Wansford Parish Council

Deadline 5 Submission

Comments on Document 9.20 Applicant's Written Summary of Oral Submissions at Hearings

A47 Wansford to Sutton Dualling

| <b>ILLUS 6</b> INTERPRETATION OF MAGNETOMETER DATA (1:1,000)                    | 11   |

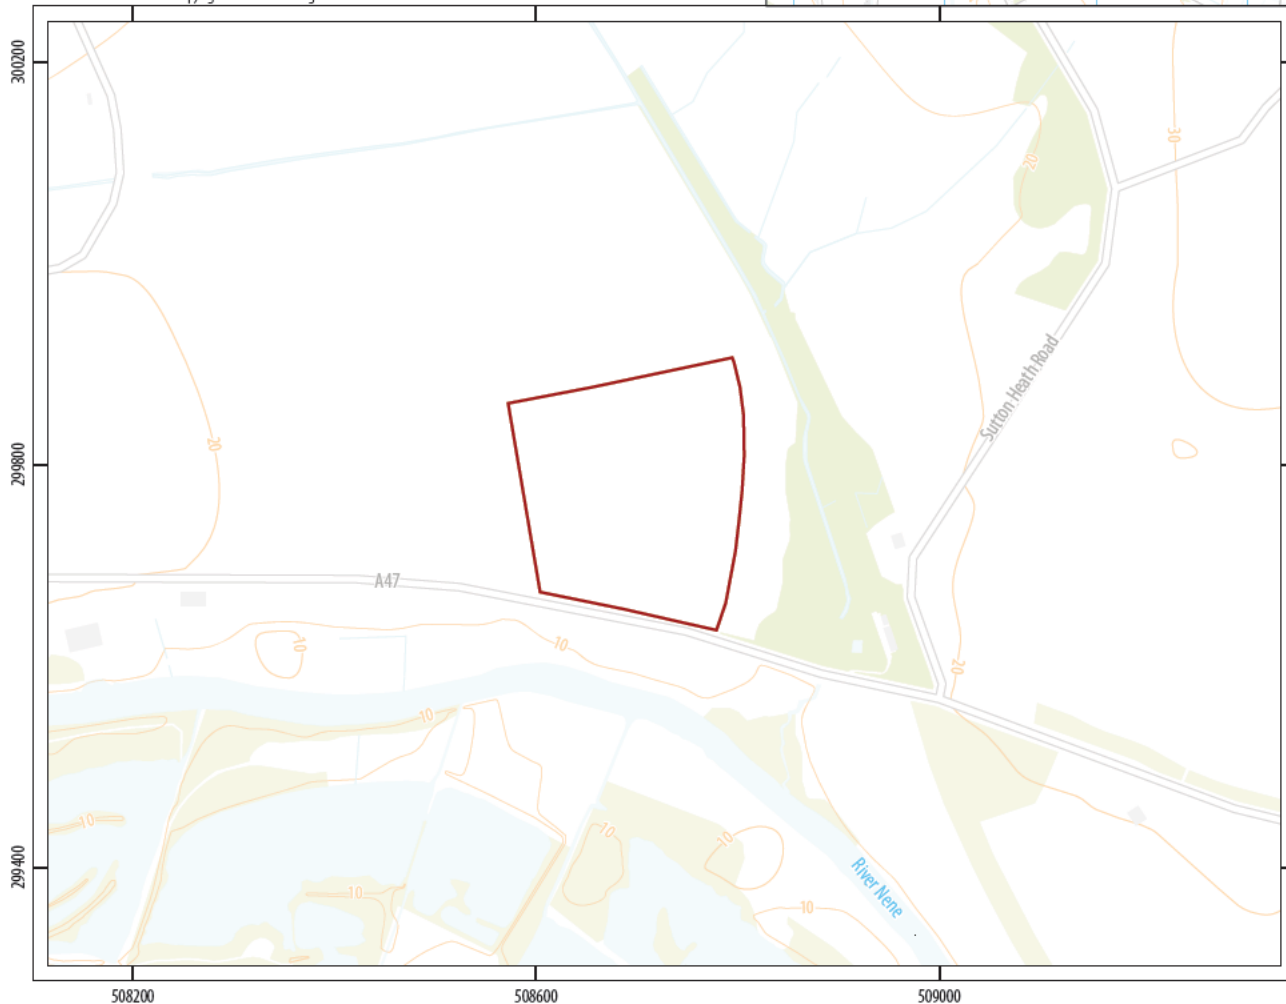
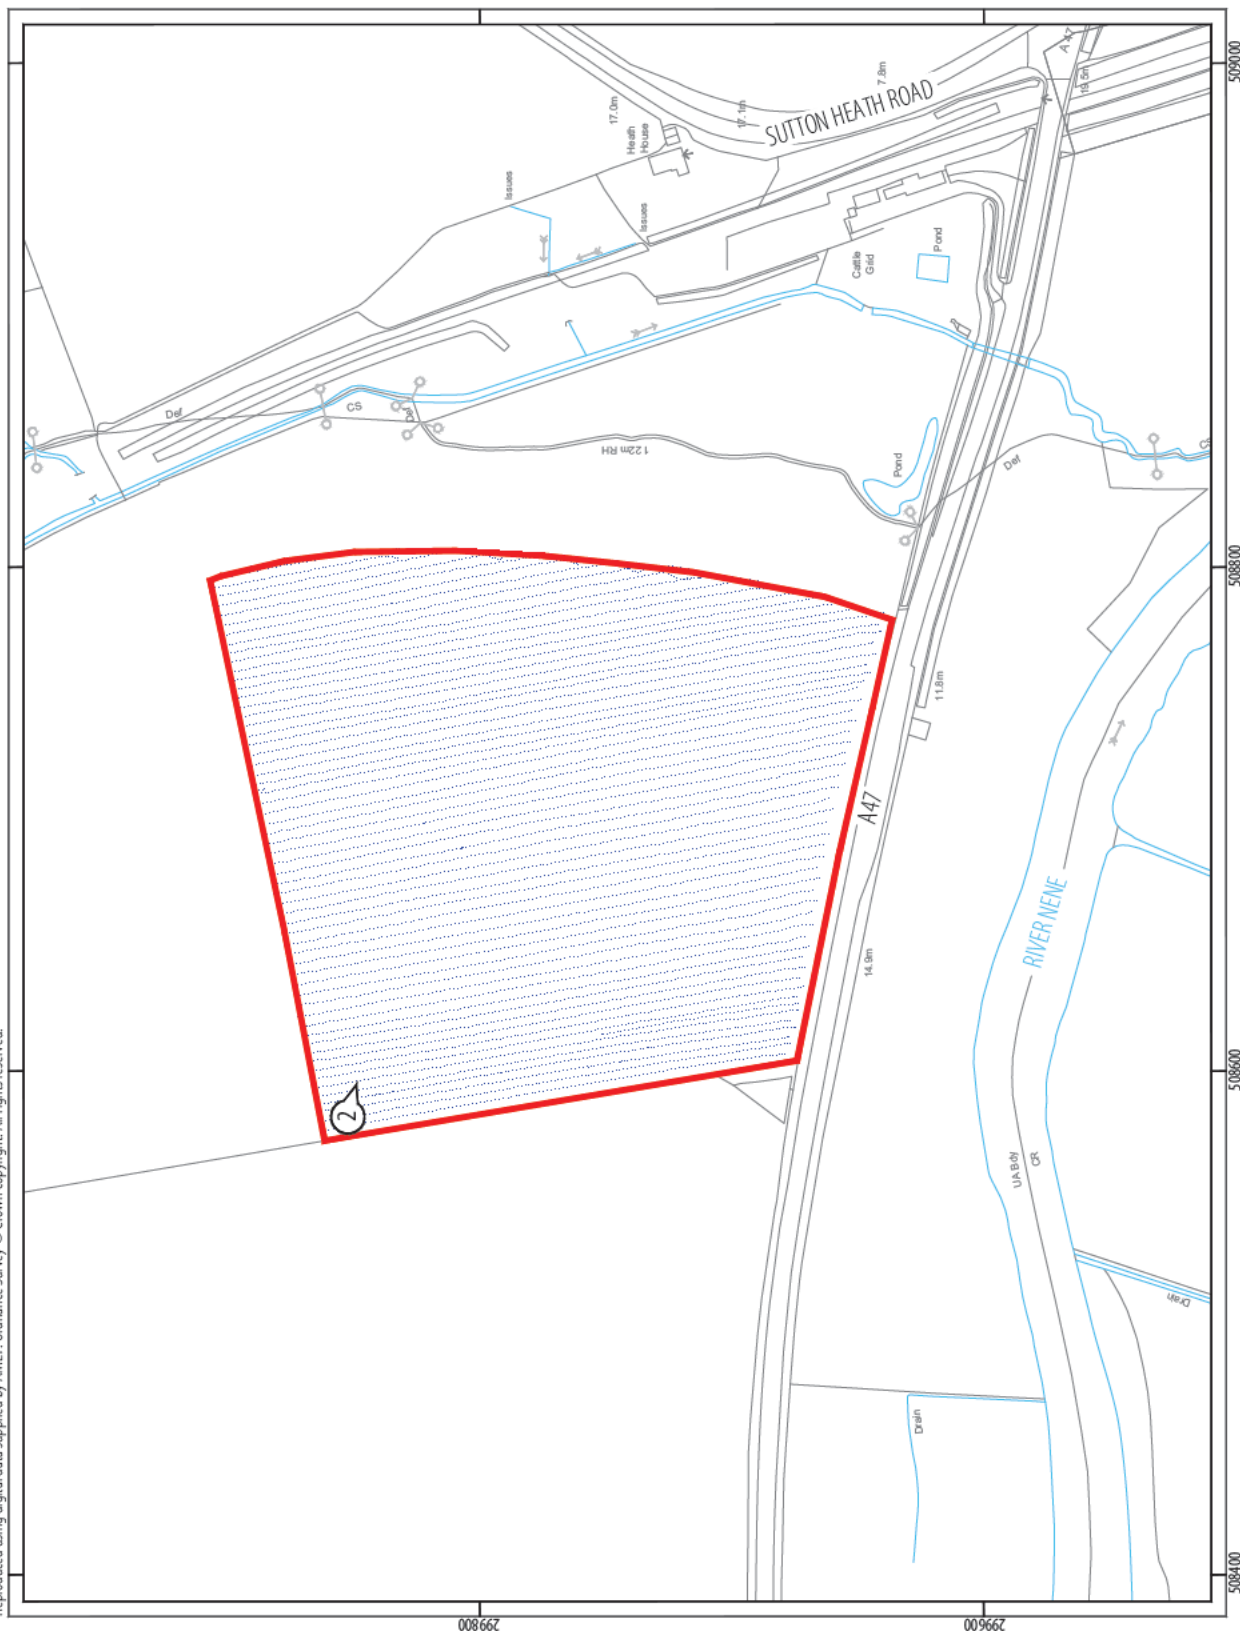
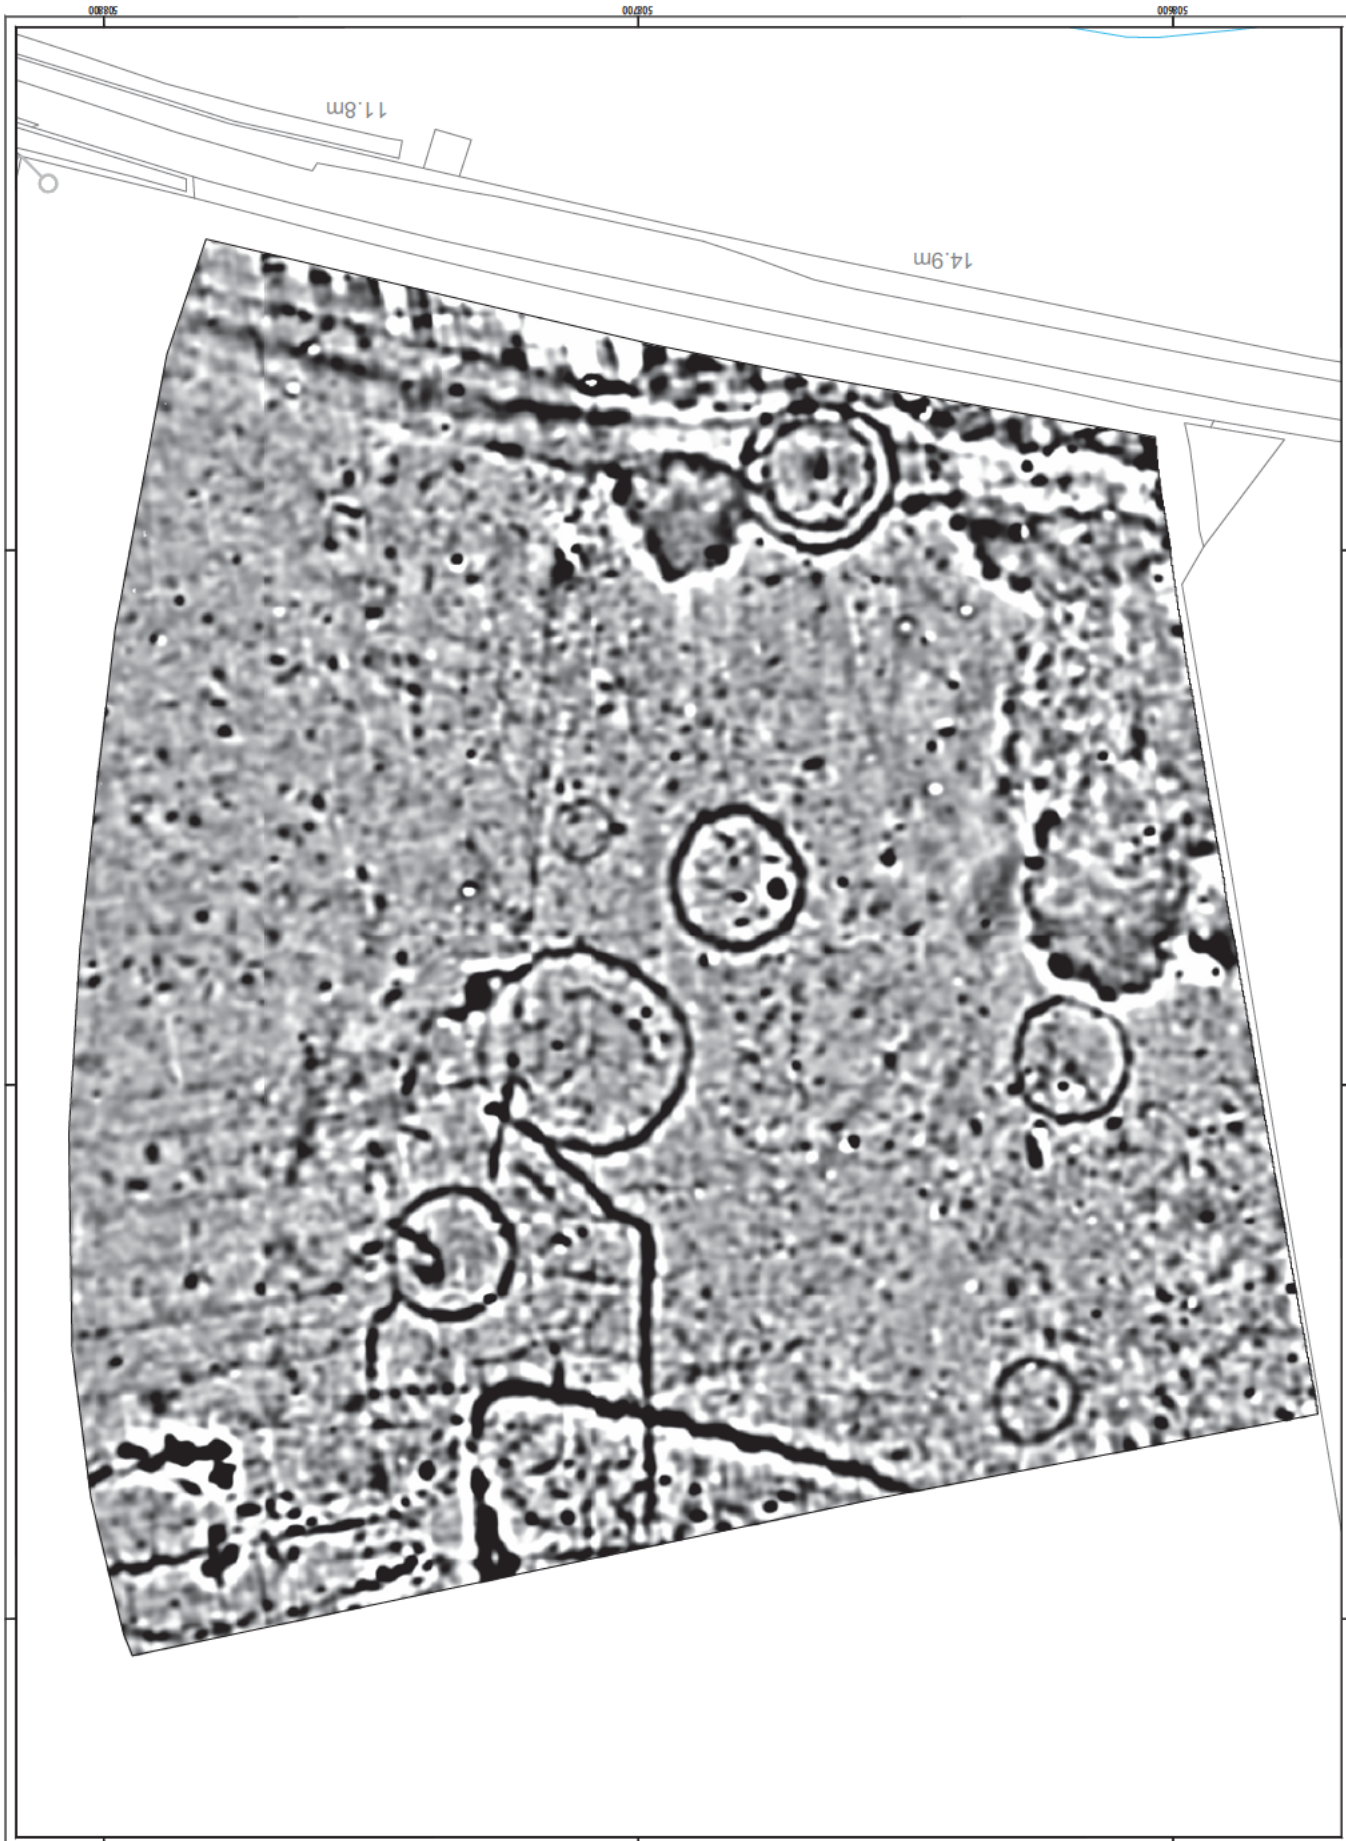
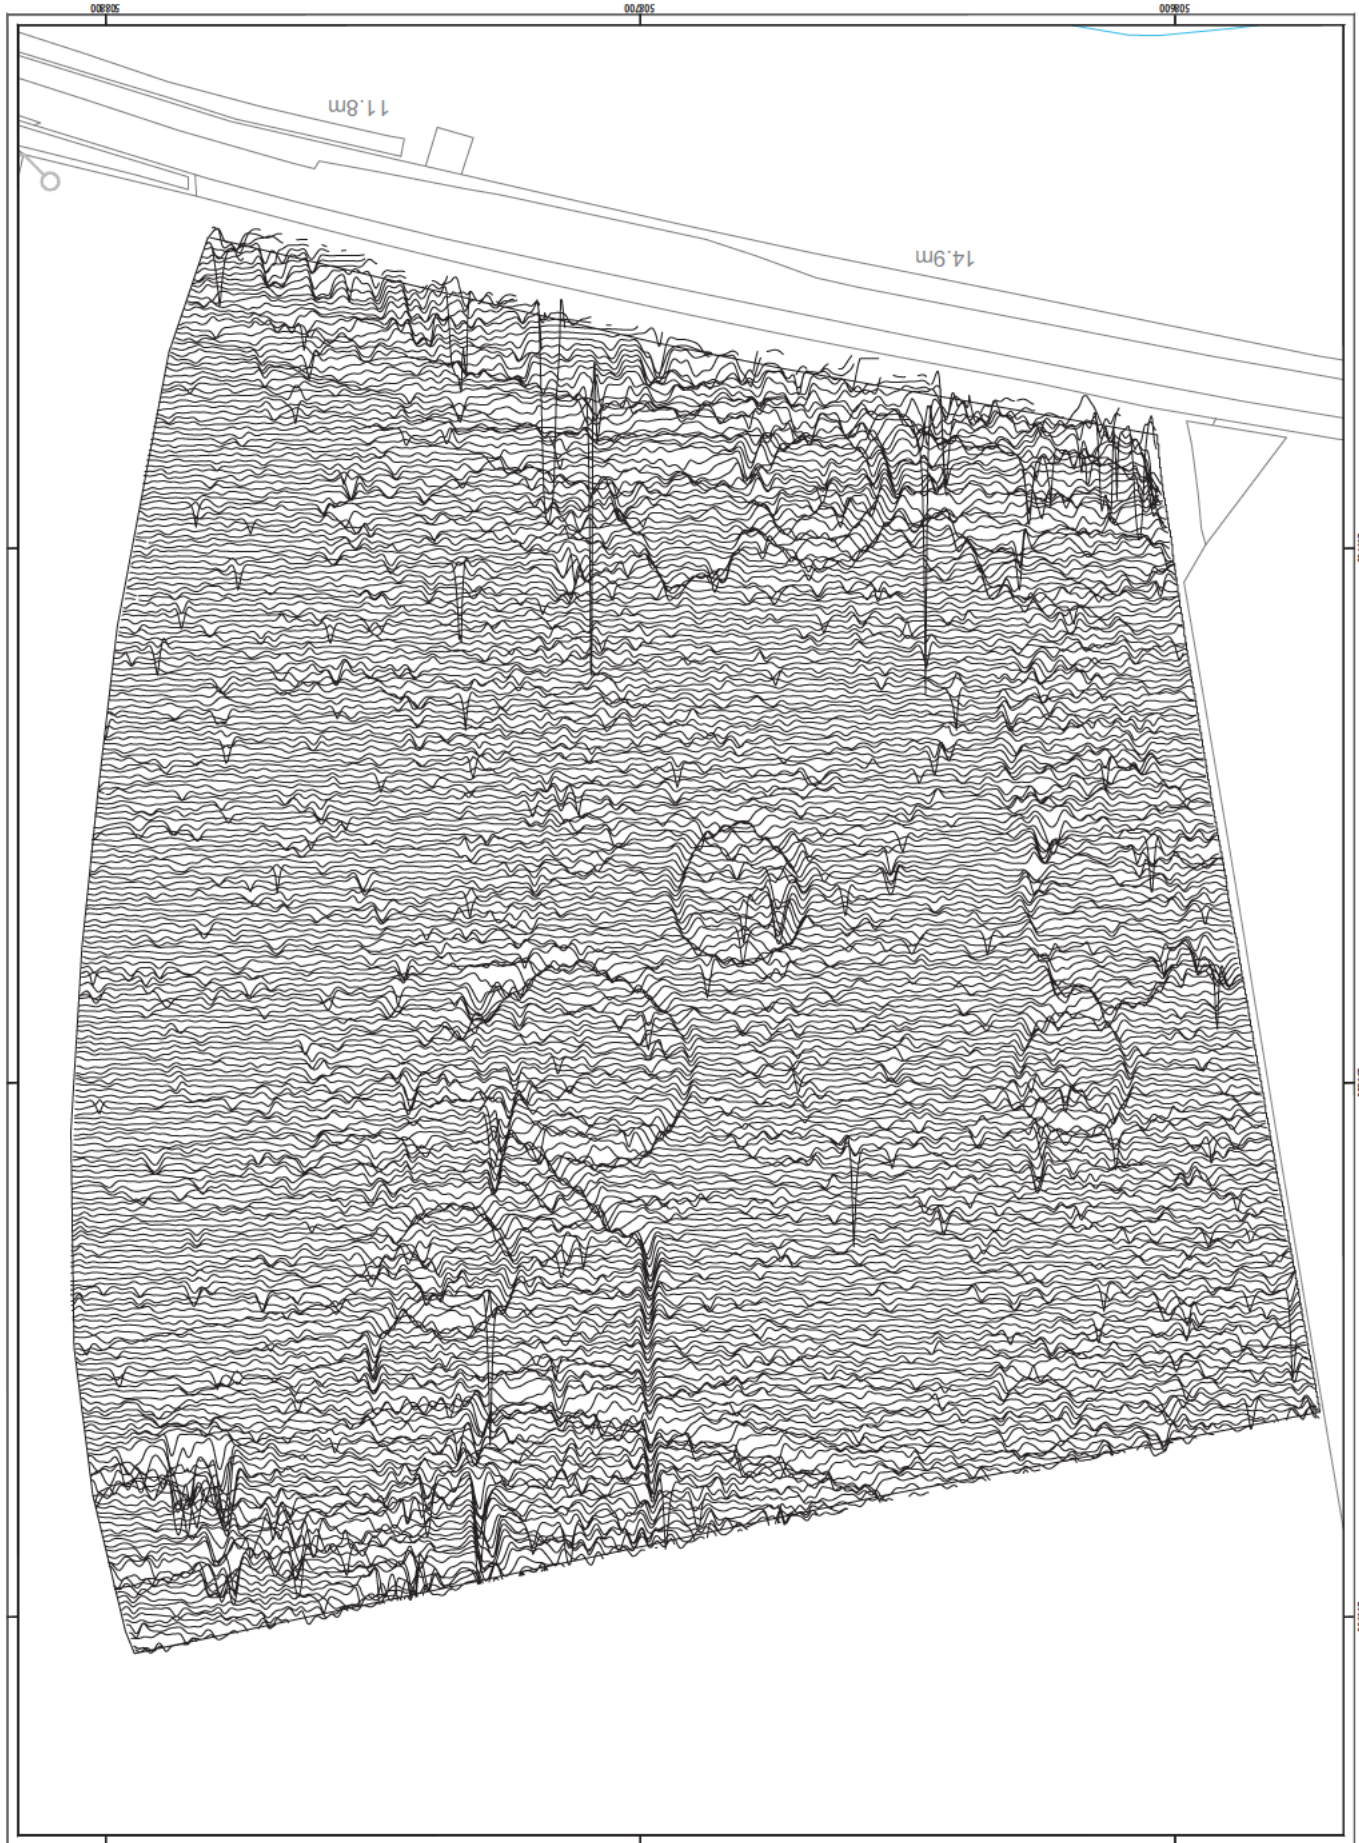
There has been repeated reference to the significance of blank spaced in the 2017 geophysical survey. The survey technique used shows up areas where there has been excavation and infilling or burning and it also shows any metallic items that may be present. The ground in the area of the Scheduled monument is free draining, alkaline and well aerated. This means that no cloth, leather or soft tissue remains will have survived (unlike at say Flag Fen where items have been preserved in acidic saturated mud). The only thing likely to be missed by the survey is pottery and this will have been destroyed by the ploughing (note the pottery fragments scattered over other parts of the site).
